From: Laura Gibbons
Sent: 13 February 2019 15:09
To: 'James Massingham'
Cc: Laura Humphries; Yuved Bheenick (Linden Homes); Gareth Hardwick; Michael Eastham
Subject: RE: Walberton - Today's Development Team Meeting

Thank you for sending through the additional information. I have the following comments:

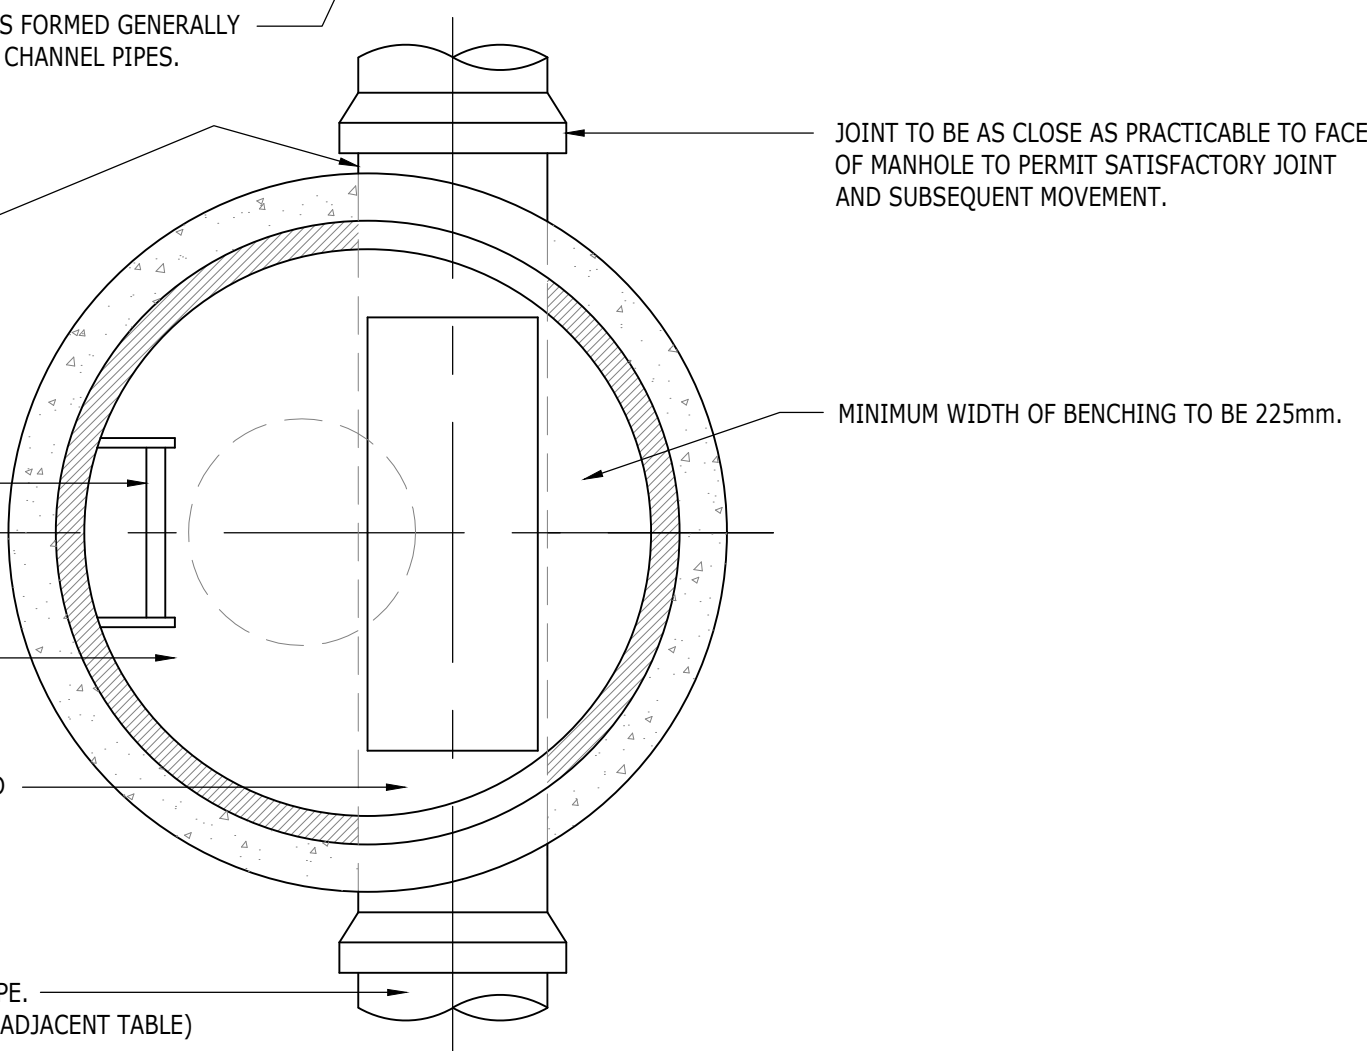
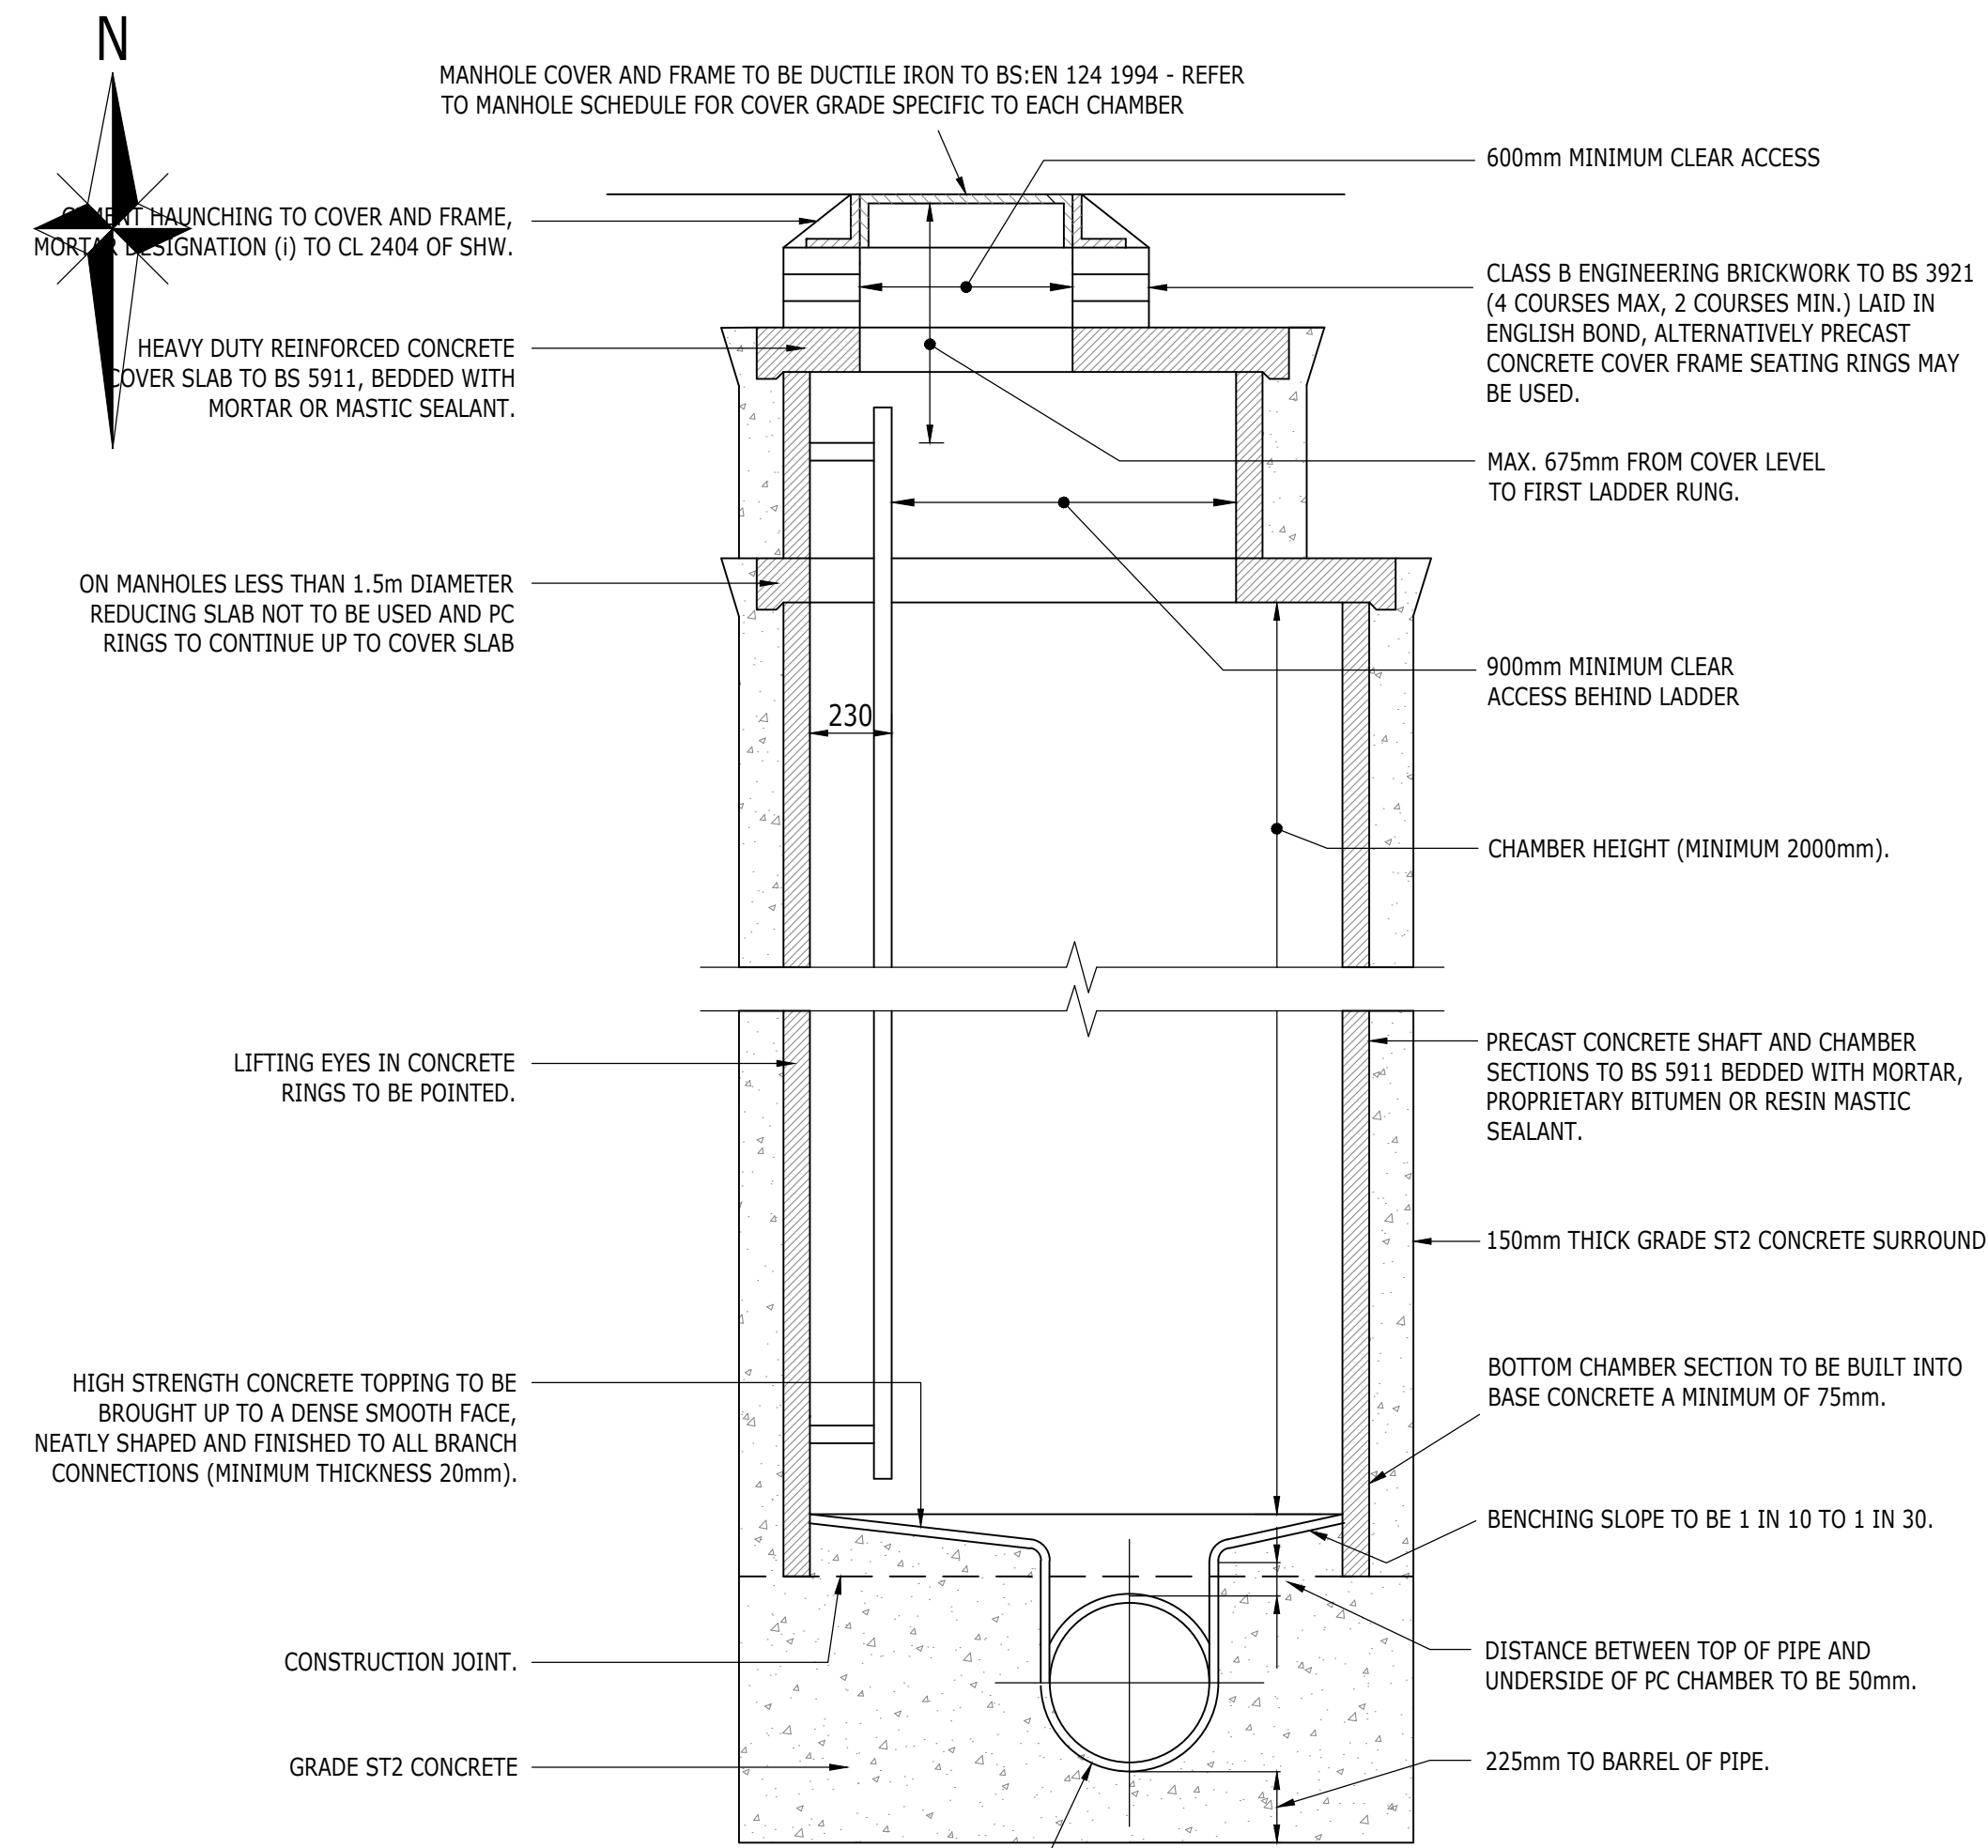
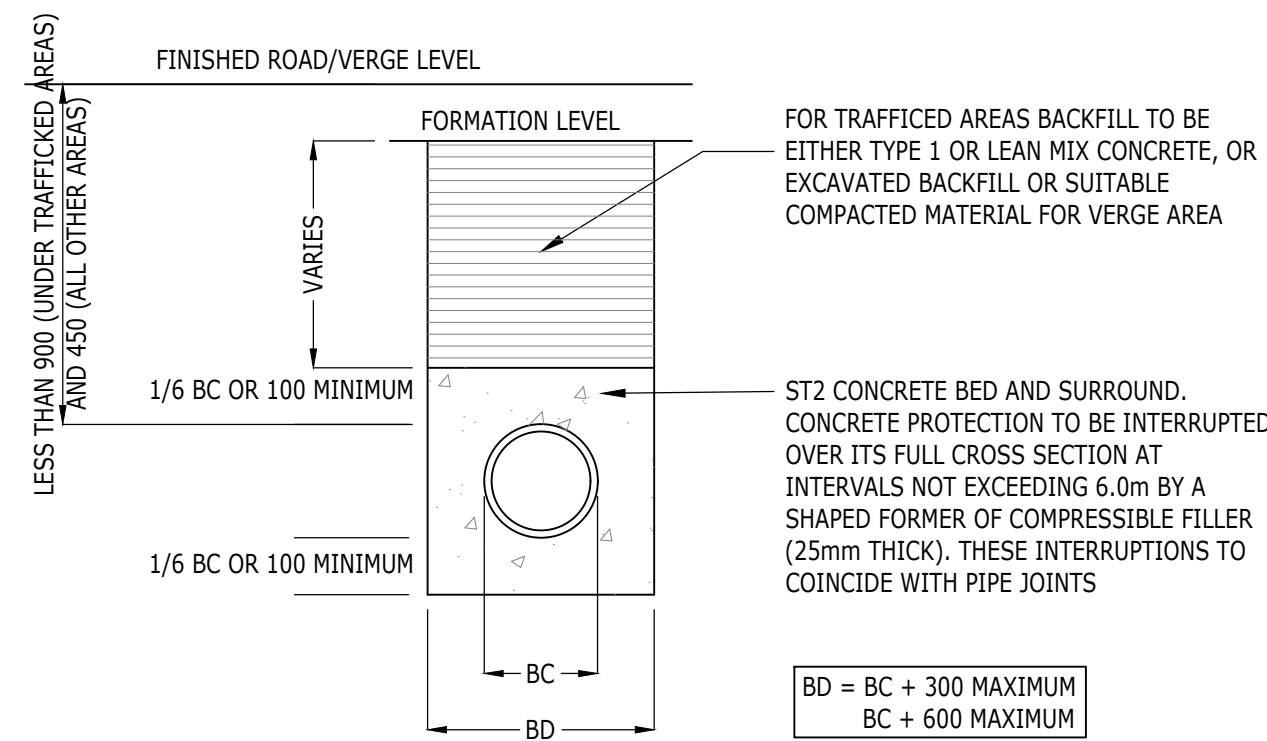
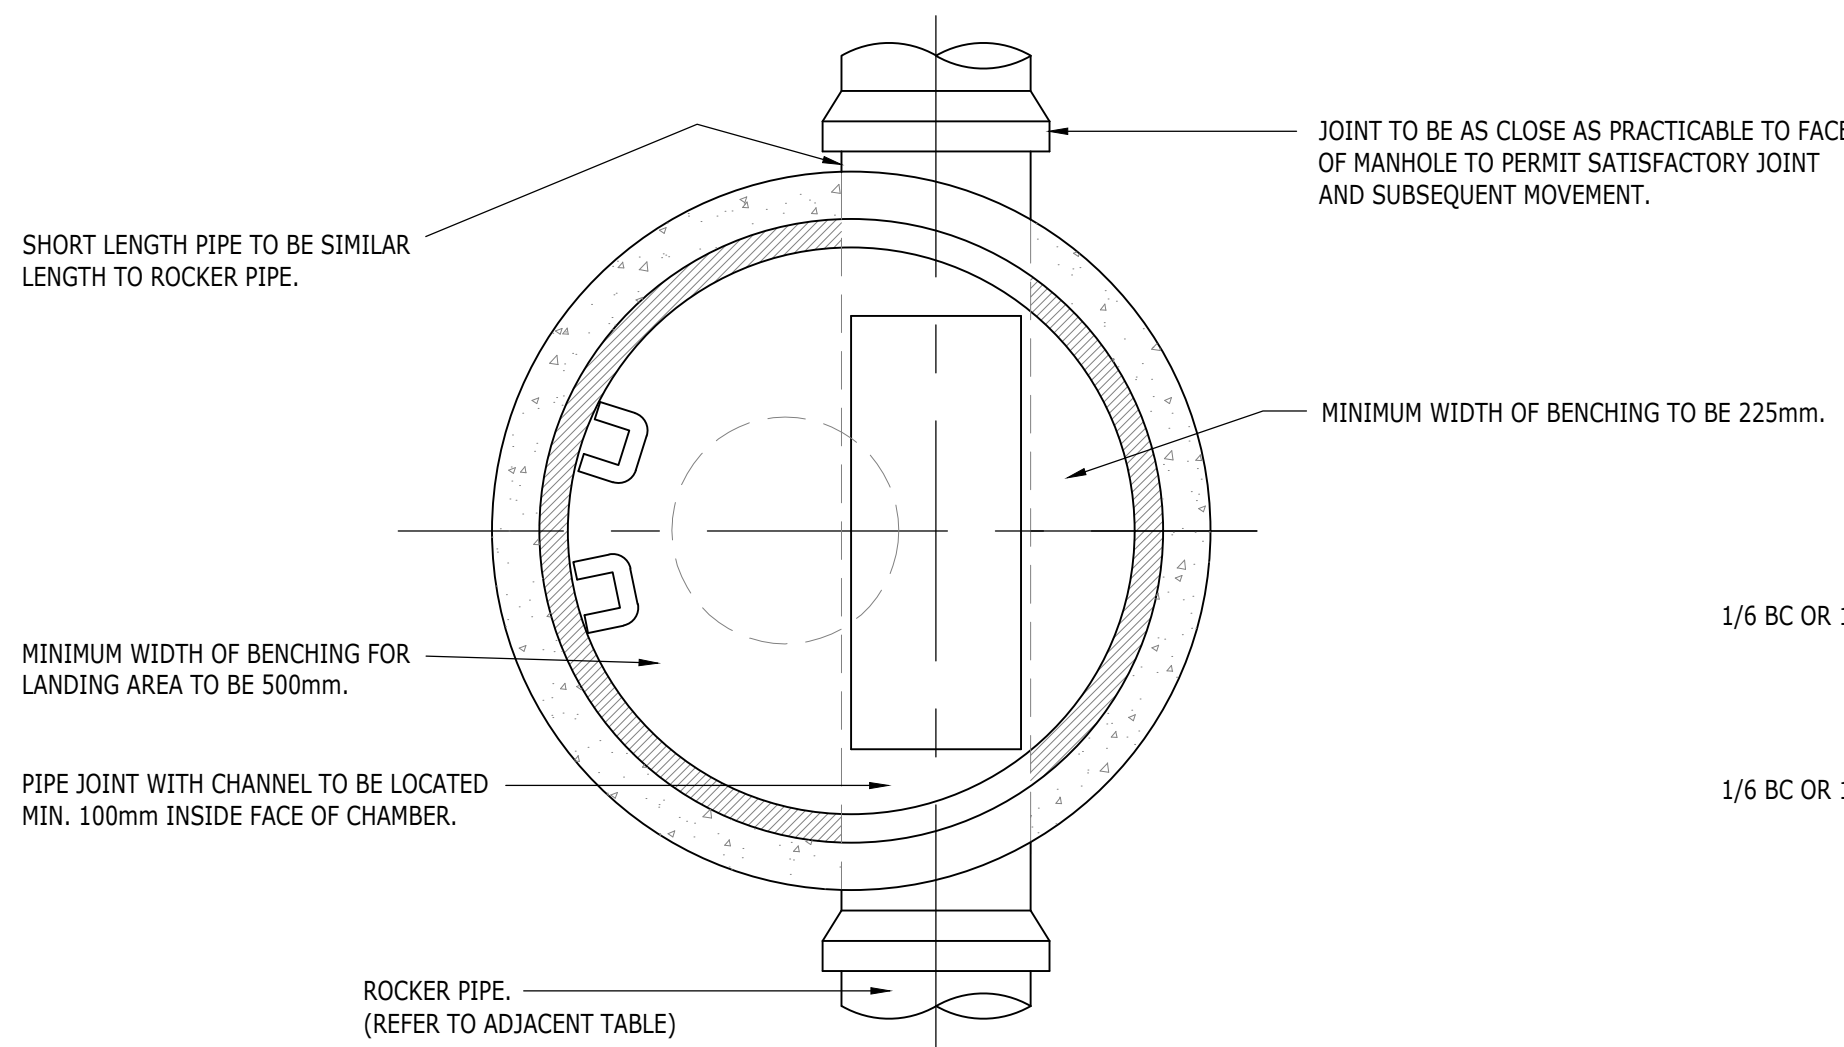
19. Please provide construction details for catchpit manhole.
20. Please provide a manhole schedule.
